Oakridge, Cow Lane, Steeple Aston, Bicester,
OX25 4SG

23/01940/F

Proposal: Demolition of existing garden building. Erection of replacement single storey garden building home study, family gym and hobby room, and garden store

drawing title
Proposed elevations, floor plans and
site plan

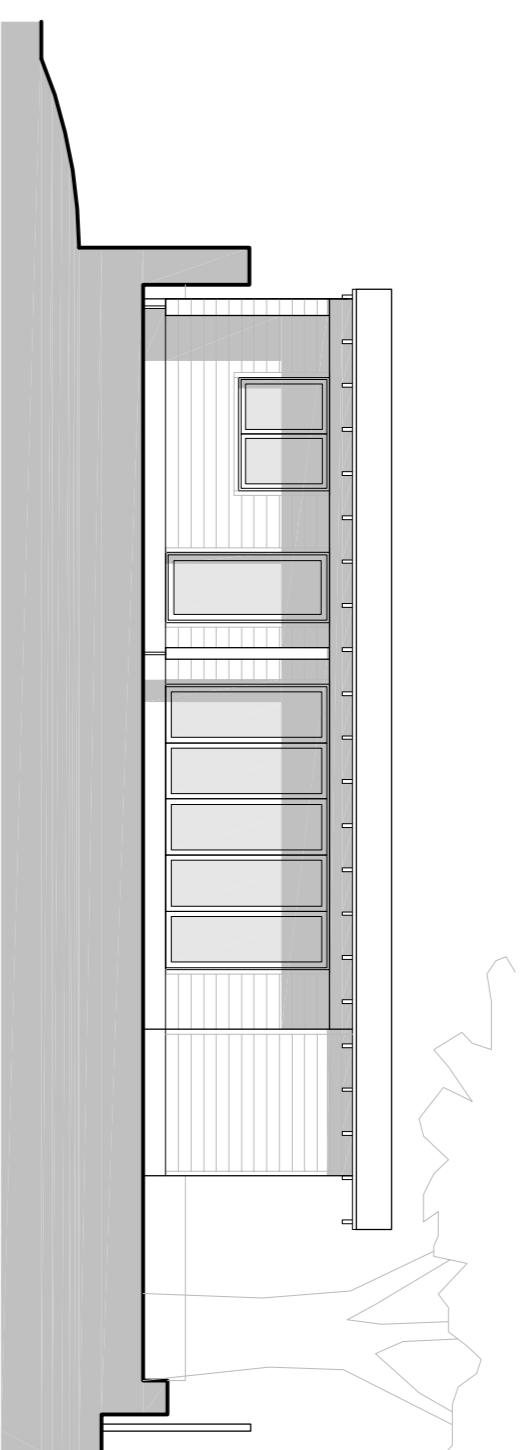
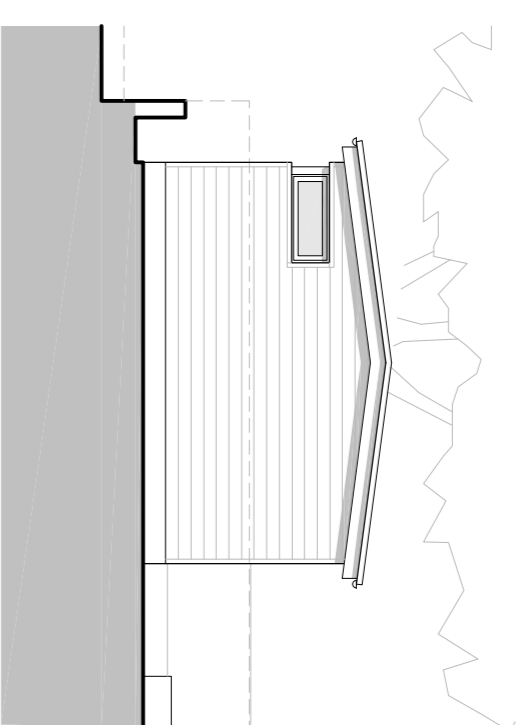
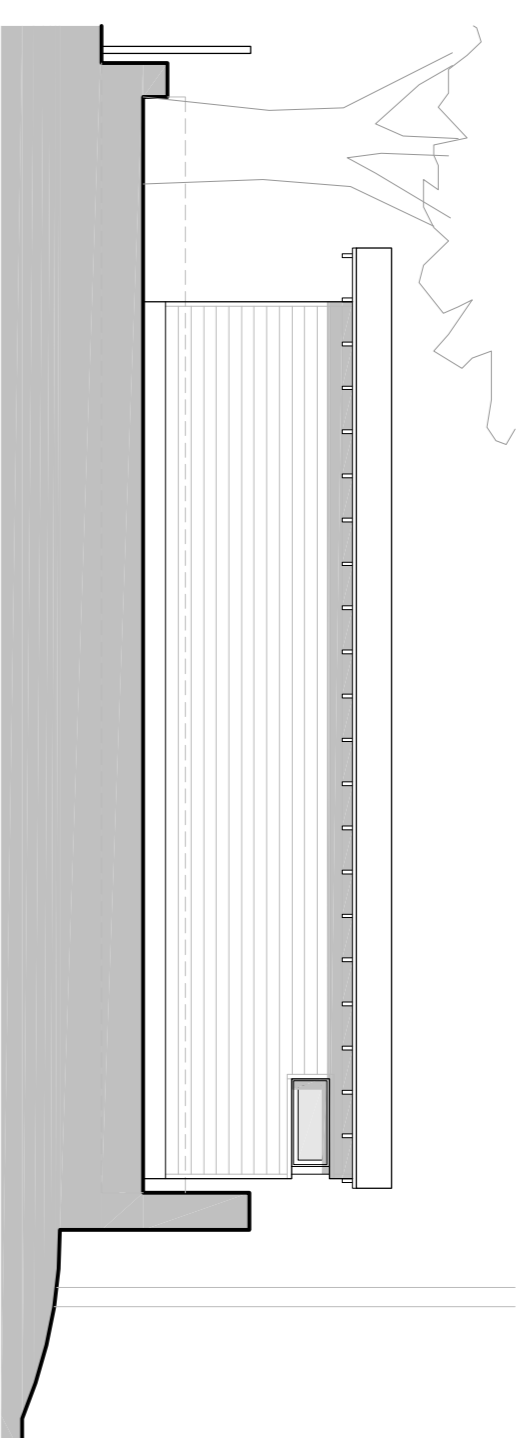
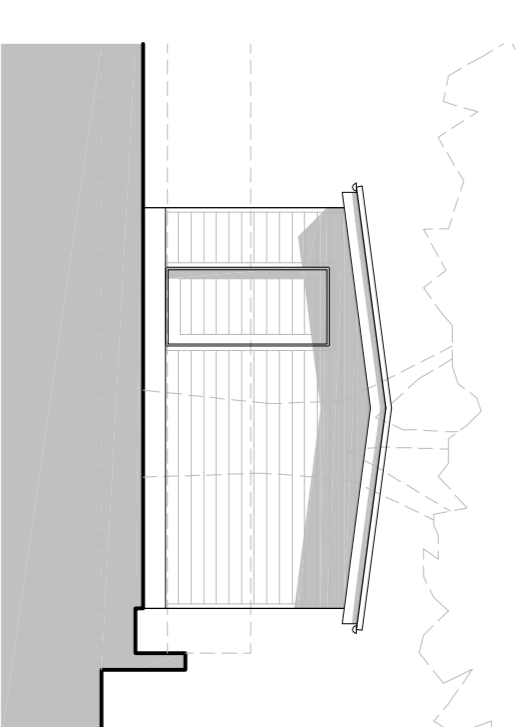
7.4. The proposed development would be positioned close to the eastern boundaries of the existing dwelling, it would be readily visible from the public realm and would have a visual impact. It would be taller. The existing building has an eaves height of 2.2m and ridge height of 2.9m, with a simple, stable block form and a dual-pitched roof. The proposed building has a similar form, but with an eaves height of 2.8m and ridge height of 3.3m. It would be more visually prominent given this height increase and a slightly greater visual impact.

7.5. However, the agent has latterly explained that tree protection requirements mean that the floor level needs to be raised and that any height lower than that proposed would present problems with construction in particular with doors opening. On balance, given the existing outbuilding it replaces and the fall-back position of an

outbuilding which can be achieved under the property's permitted development and which would also be visible from the public realm, and seen in the context of the existing dwelling and other existing built form, the proposal would not adversely affect the character and appearance of the area.

TREE CONSTRAINTS PLAN

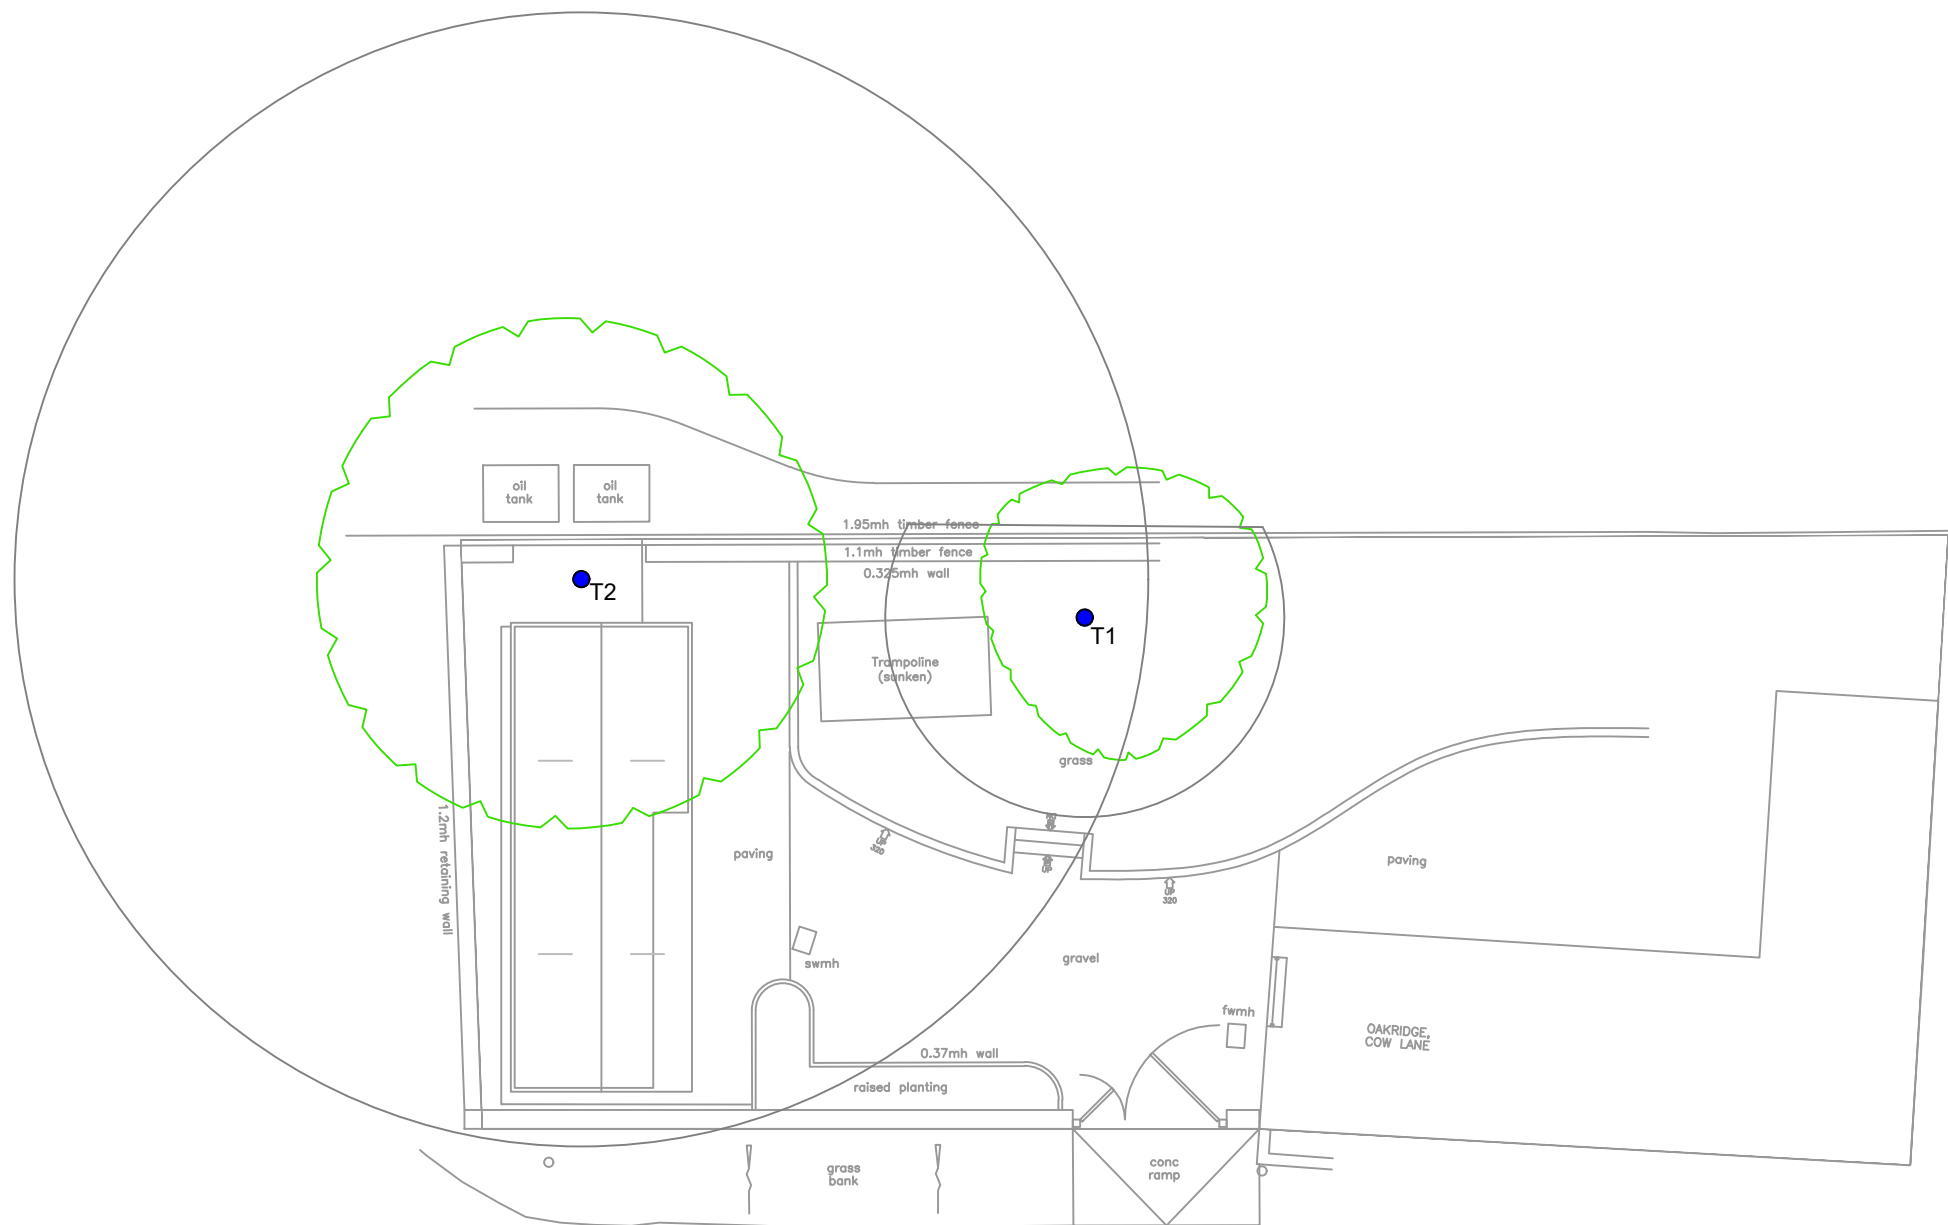
Arboriculture - I have looked at the proposals and I have no real issues. An assessment was carried out of the rooting environment of the Horse Chestnut, which is protected by a TPO, and it was determined that no significant roots will be affected by the proposals but as a precaution screw piles will be used. What is lacking is a Tree Protection Plan and an arboricultural method statement. These will both be a requirement but can be dealt with by way of condition of any consent given. Both these will need to be produced in accordance with BS5837:2012.

- 7.12. An Arboricultural Impact Assessment (AIA) has been submitted with the application.
- 7.13. The Arboricultural Officer (AO) advises that an assessment was carried out of the rooting environment of the Horse Chestnut, which is protected by a TPO, and it was determined that no significant roots would be affected by the proposals but as a precaution screw piles would be used. The AO further advises what is lacking is a Tree Protection Plan and an Arboricultural method statement. In order for the proposals to be acceptable in terms of arboricultural impact, the Tree Protection Plan and an Arboricultural method statement - to be produced in accordance with BS5837:2012 - would both be necessary but can be dealt with by way of condition of any consent given.

4. No development shall commence unless and until an Arboricultural Method Statement (AMS) detailing the tree protective measures/procedures and including a tree protection plan, to be undertaken in accordance with BS:5837:2012 and all subsequent amendments and revisions, has been submitted to and approved in writing by the Local Planning Authority. Thereafter, all works on site shall be carried out in full accordance with the approved AMS and tree protection plan.
